From: [Malgy Coman](#)
To: [Shaun Williams](#)
Subject: RE: Oakdale West Estate Modification 1 (SSD 7348 MOD 1)
Date: Monday, 10 February 2020 5:50:20 PM

Reference is made to your email dated 13 January 2020 regarding the modification application MOD 1 for the Oakdale West Estate SSD. Transport for NSW notes that minor increases to the approved Gross Floor Area are proposed for MOD 1 and as such raises no objection to the proposed modifications as it is unlikely to have a significant impact on the classified road network.

Figure 4 Site Access

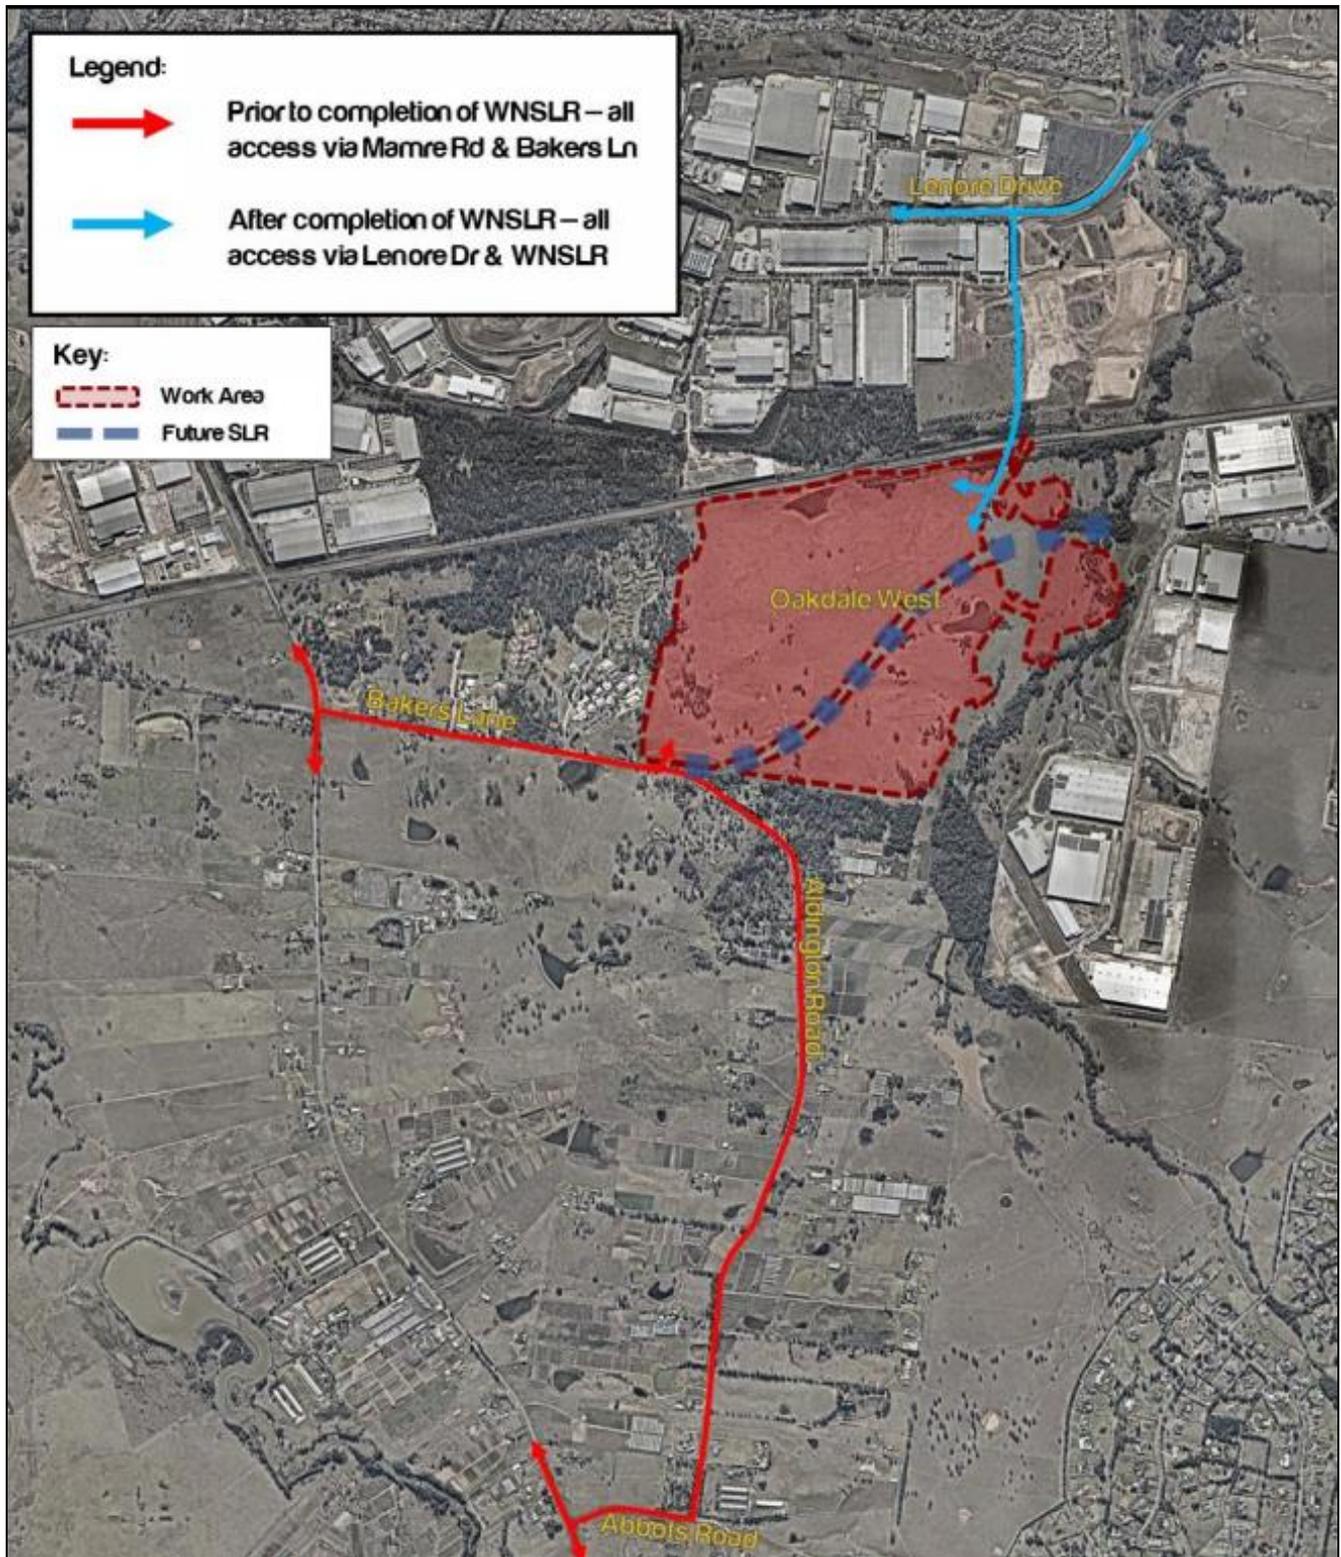
With regard to any proposed construction access arrangements on Mamre Road via the Water NSW pipeline access route, please see the following comments:

- The existing Water NSW pipeline access point on Mamre Road will require a left-in/left-out construction vehicle arrangement and road safety mitigation works to safely accommodate simultaneous entry/egress to the satisfaction of TfNSW. These works require concurrence from TfNSW in accordance with Section 138 of the Roads Act, 1993 and a Works Authorisation Deed.

- Road safety mitigation works would need to adequately address TfNSW concerns regarding the merge point from two lanes into one lane located close to this access point. There are concerns that drivers focusing on the merge may not notice a construction vehicle slowing down just beyond the merge, potentially resulting in a rear-end crash.

- The current posted speed limit is 80km/hr and a design speed of 90km/hr needs to be considered in road safety mitigation works for the construction vehicle access.

- The developer will need to adequately address potential driver confusion for situations where construction vehicles are slowing down before the merge point whilst motorists are accelerating to merge at this location.
